1210 Brighton Avenue - Updated Traffic Comments

Hi Nell – The following is a status update of my comments emailed on May 5, 2017.

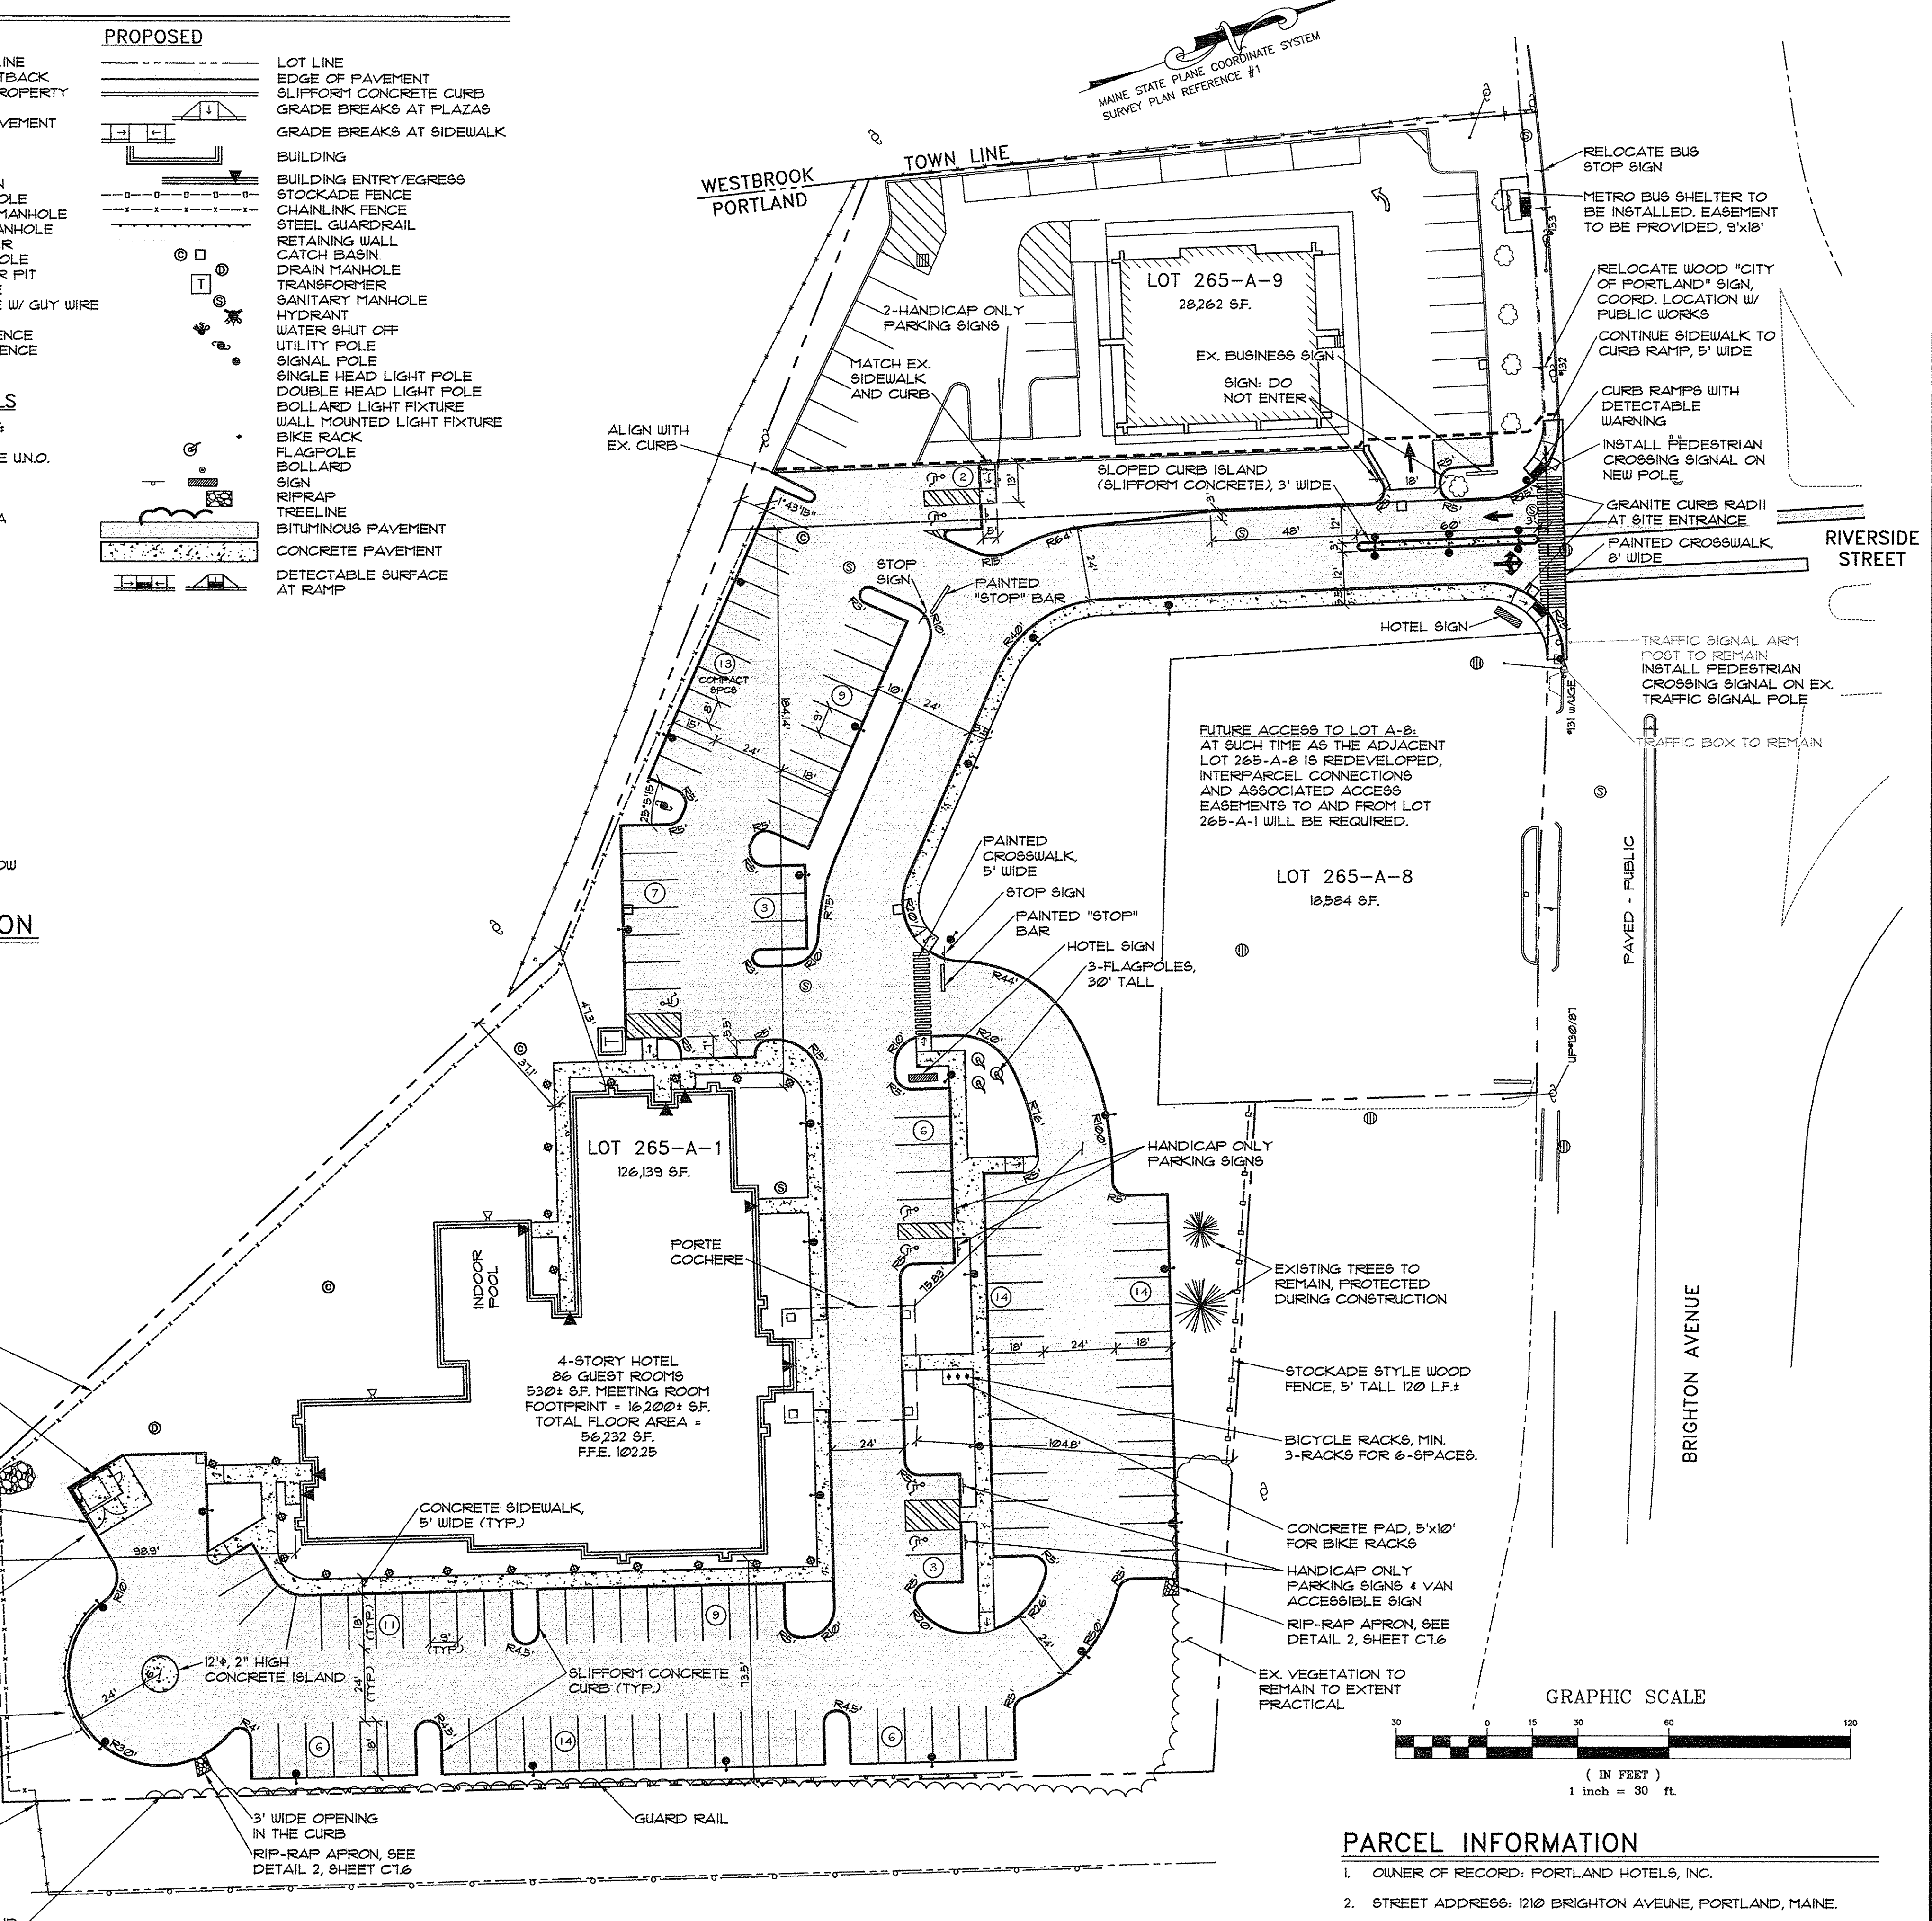
- The applicant should provide supporting information regarding the design of the internal intersection (where the crosswalk is provided). The information should respond to the following issues:
 - The geometric alignment of the intersection, particularly the use of pavement markings to define the intersection configuration. I would suggest auto-turn information be provided.

- The location of the crosswalk in relationship to the STOP bar may create unsafe conflicts.

- I would prefer alignment with the opposite parking lot driveway.

- The design should consider a future pedestrian connection through Lot 265 A-8 to Brighton Avenue.

Status: During the original review of the project it was noted that pedestrians originating from the hotel with destinations to Brighton Avenue (inbound) would benefit if a pedestrian connection is provided through Lot 265 A-8. This site plan does not provide a connection to Lot 265 A-8 and would need to be retrofitted when the noted connection is provided. The applicant should acknowledge that this would be required during redevelopment of Lot 265 A-8.

Status: The revised plan is acceptable (although the above comment could impact this intersection).

Status: The revised plan is acceptable.

Status: The revised plan is acceptable.
